Application for Planning Permission for Works or Extension to a Dwelling

Development: Proposed new slate roofed porch to rear door.
Proposed new back door to replace existing rotten door.
Proposed new insulated roof access window to provide maintenance access to butterfly roof valley.
Replace broken slates and refix slipped slates
Various timber repairs to windows to rear elevation.
Rearrange lower ground floor to swap exiting Kitchen with Dining Area
New steel garden gate.
Relay foul drain in garden, replace i.c covers. Connect to existing invert.

Location: 17 Maltravers Street Arundel BN18 9AP

Location Plan

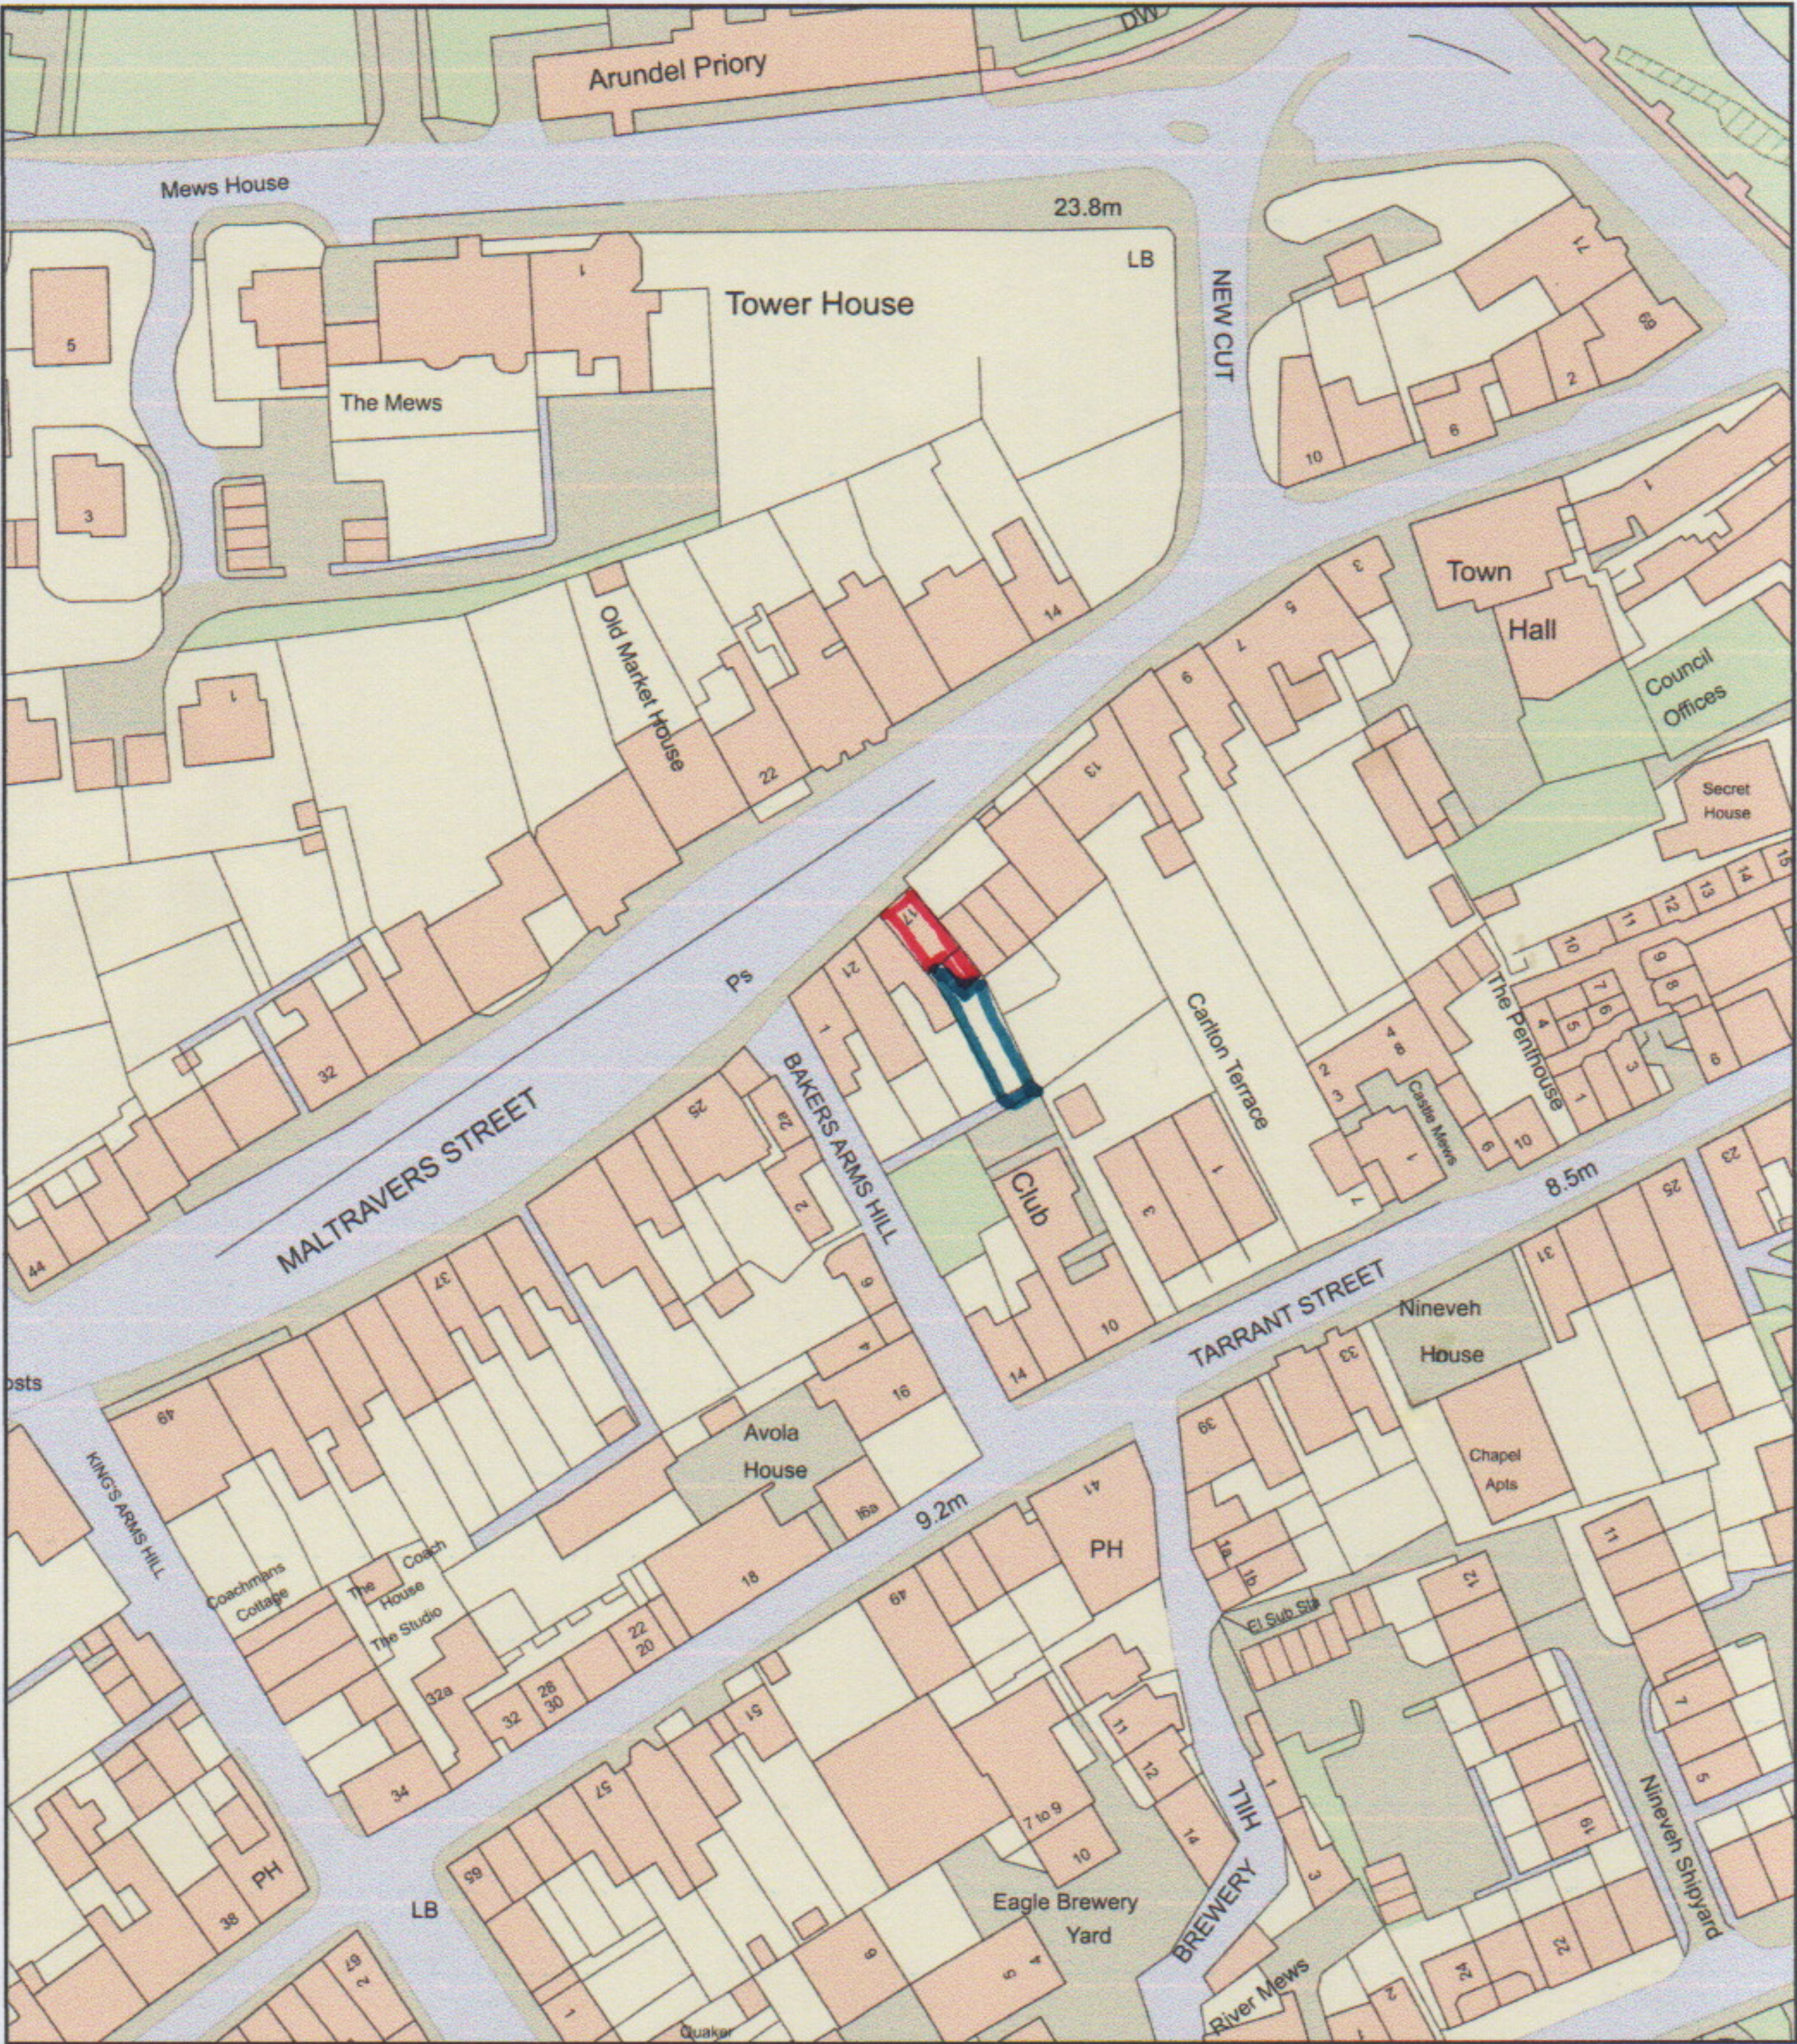
Location Plan: The entire site needs to be included within the red outline on the location and block plan. Please amend
